Planning Application R/90/18/HH, 9 Park Drive, Rustington.

I wish to raise an objection in respect of the updated planning application R/90/18/HH for 9 Park Drive, Rustington.

203 Proposed East Elevation

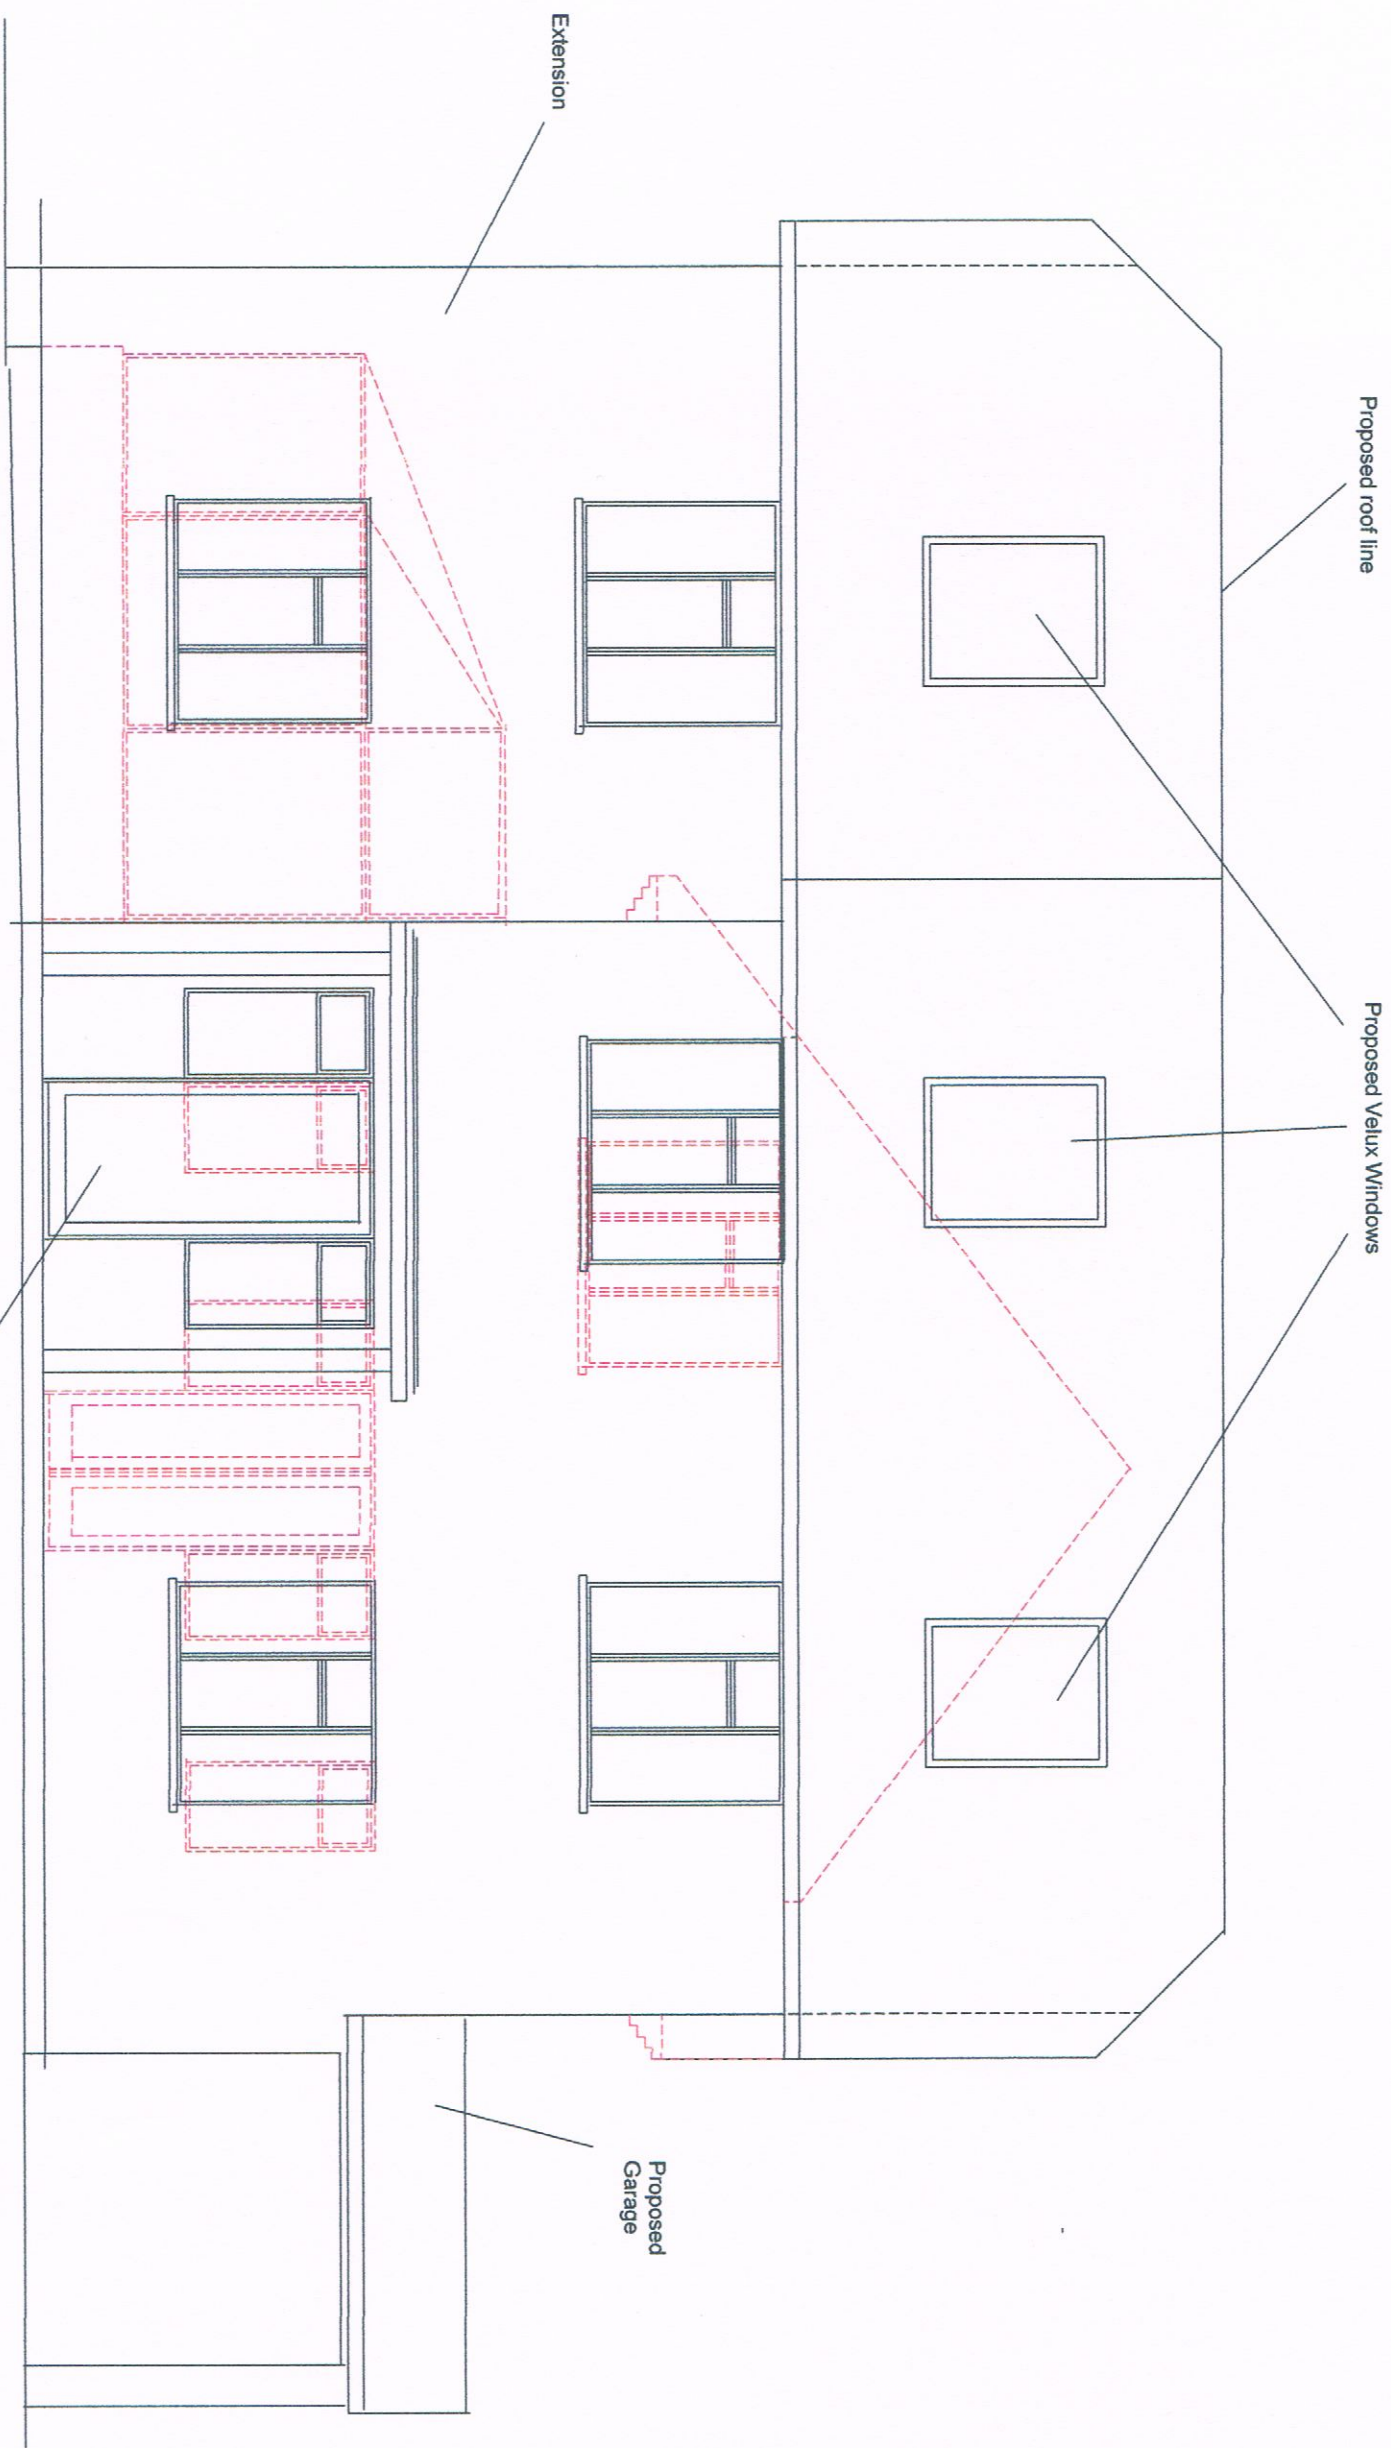
I am concerned that the patio doors/windows servicing the flat roof will look directly at my property. Also, the larger windows proposed at either end of the roof, which appear on the drawing to be at a slightly different angle to the Velux windows, will overlook my property to a potentially greater extent than previously.

Proposed West Elevation

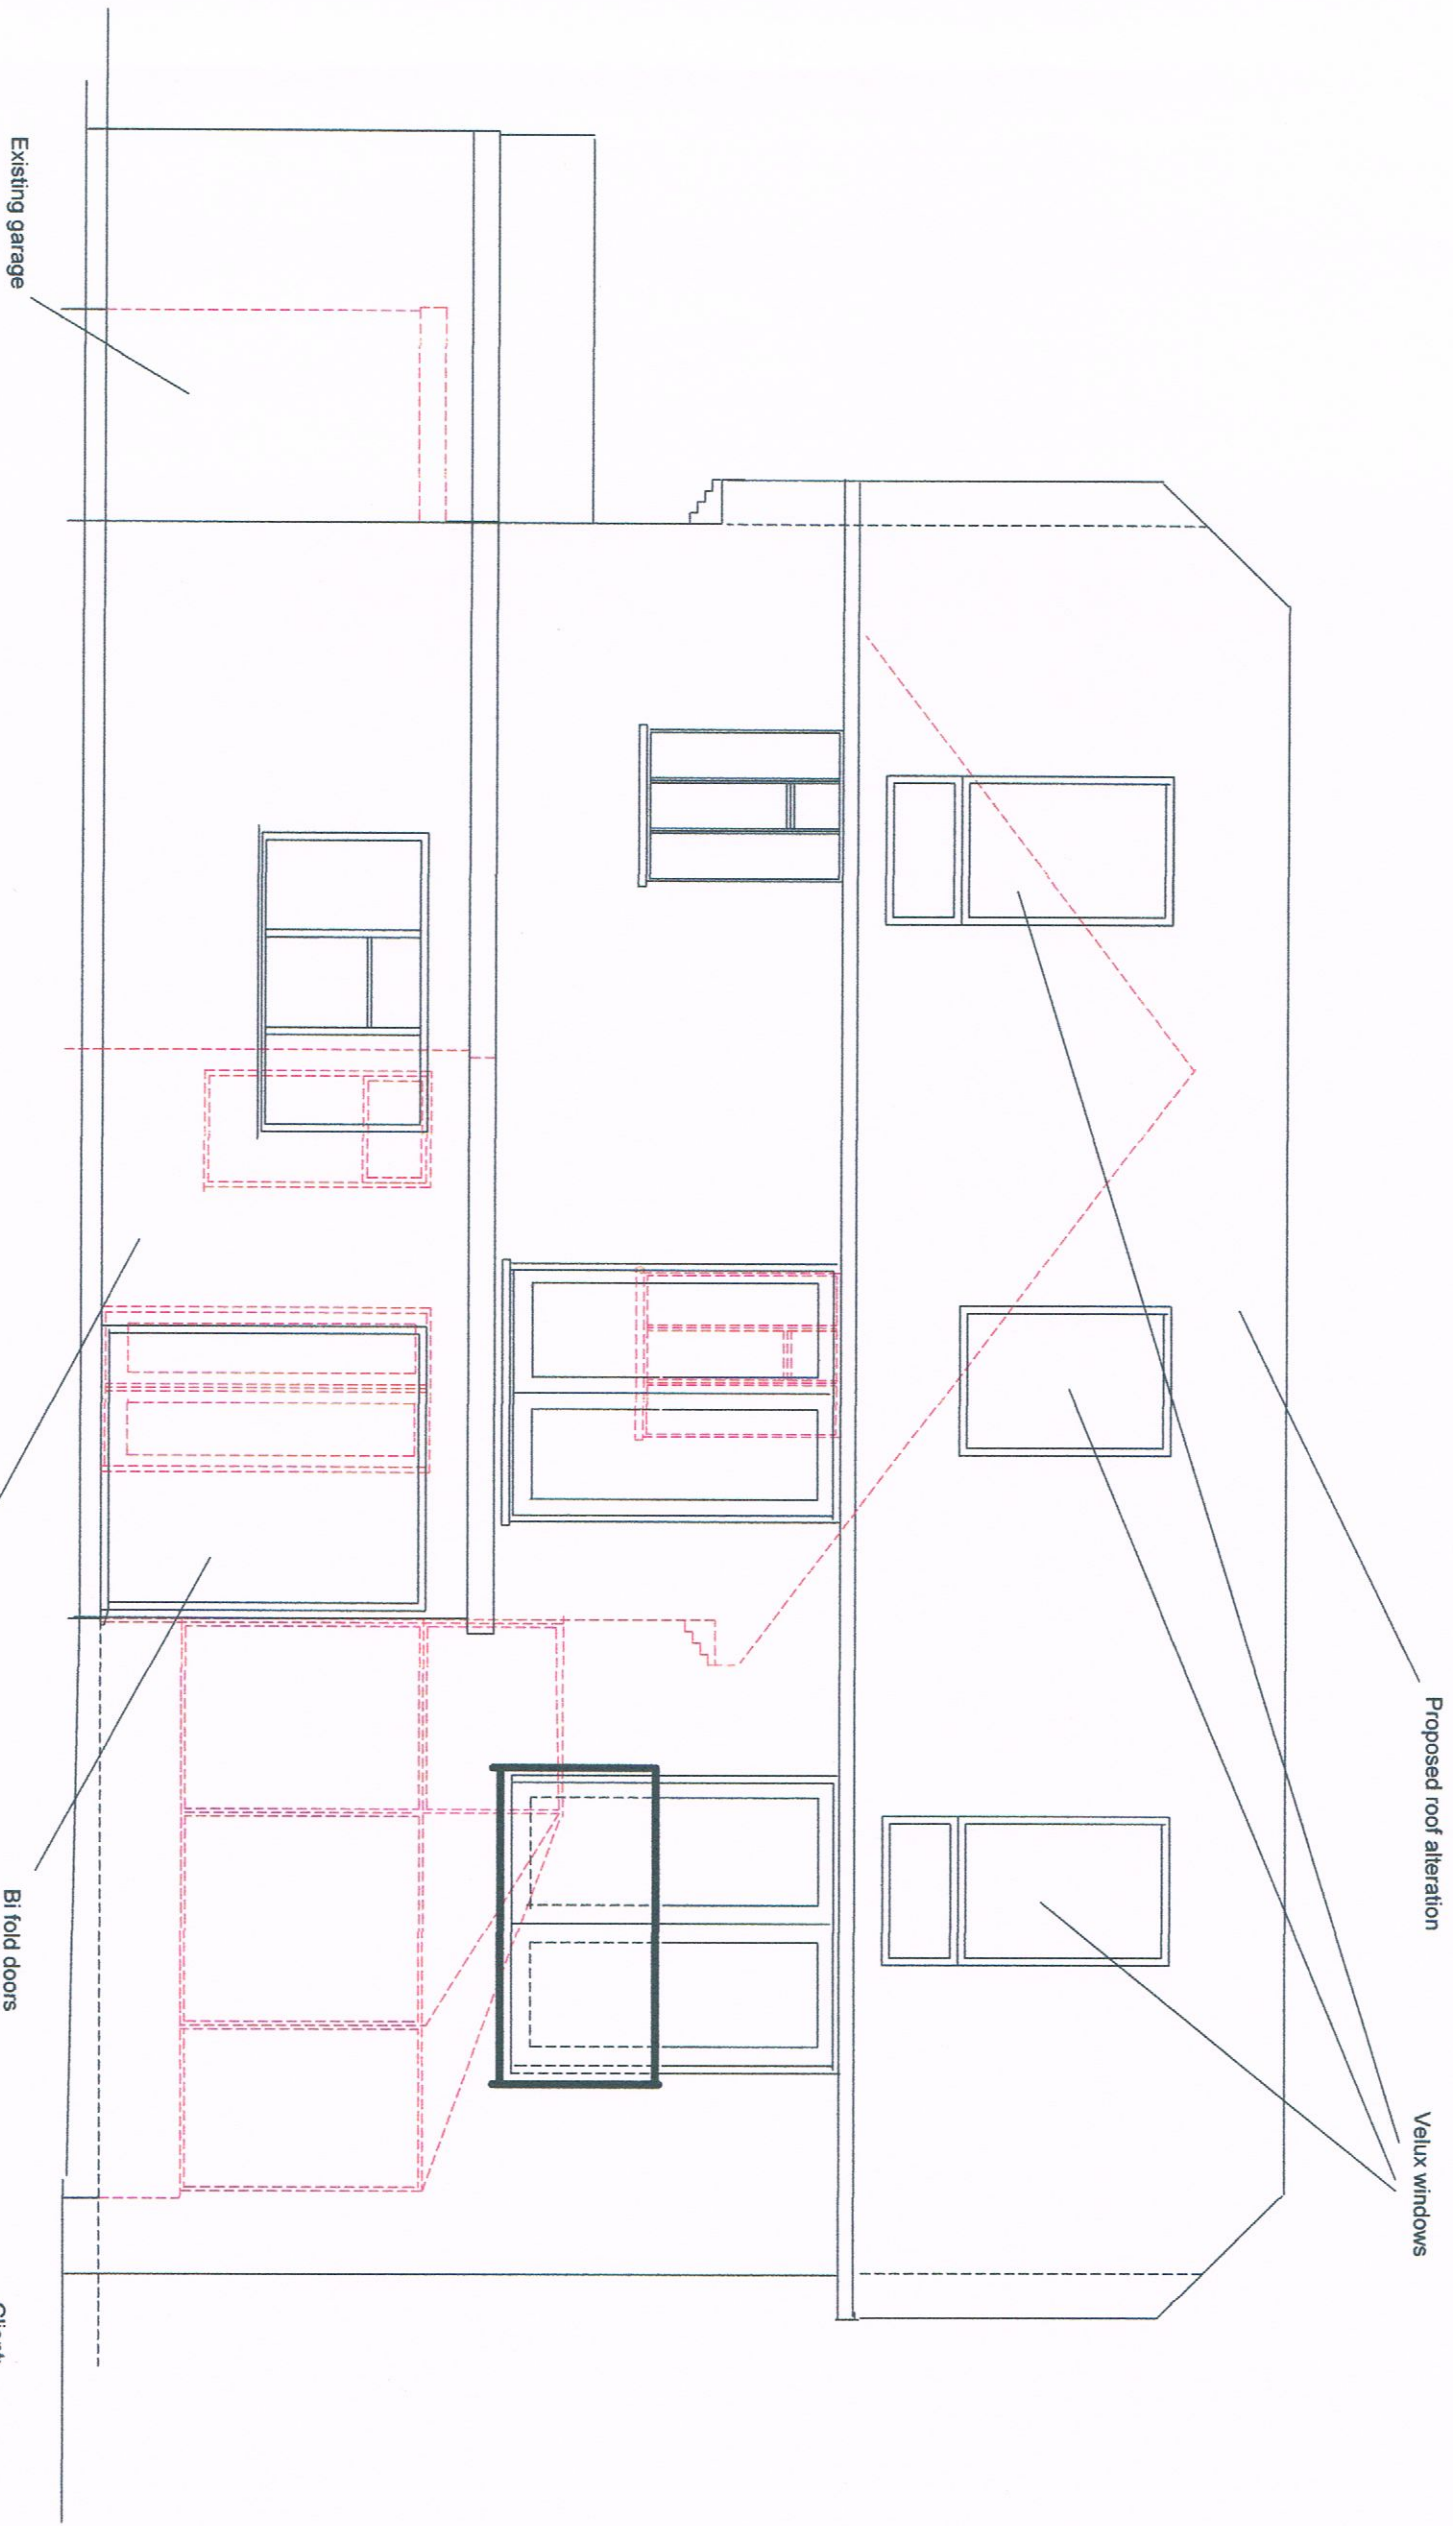
The revised plans may show a minor reduction in the height of the roof line, but it remains a proposed three storey property which will overlook my property from the rear of the 2nd floor. Furthermore, the flat roof balcony area remains, as does the full height patio door which leads to the said balcony.

Although the minor decrease in height of the roof is welcome, it does not significantly alter the principle that this will change from a two storey to a three storey property and overlook my back garden. I therefore wish to register my objection to this application. In particular, I strongly oppose the window/doors leading out onto a flat roof and the larger windows at each end of the roof, whereby the lower part of the window appears to be vertical and will look over my property.
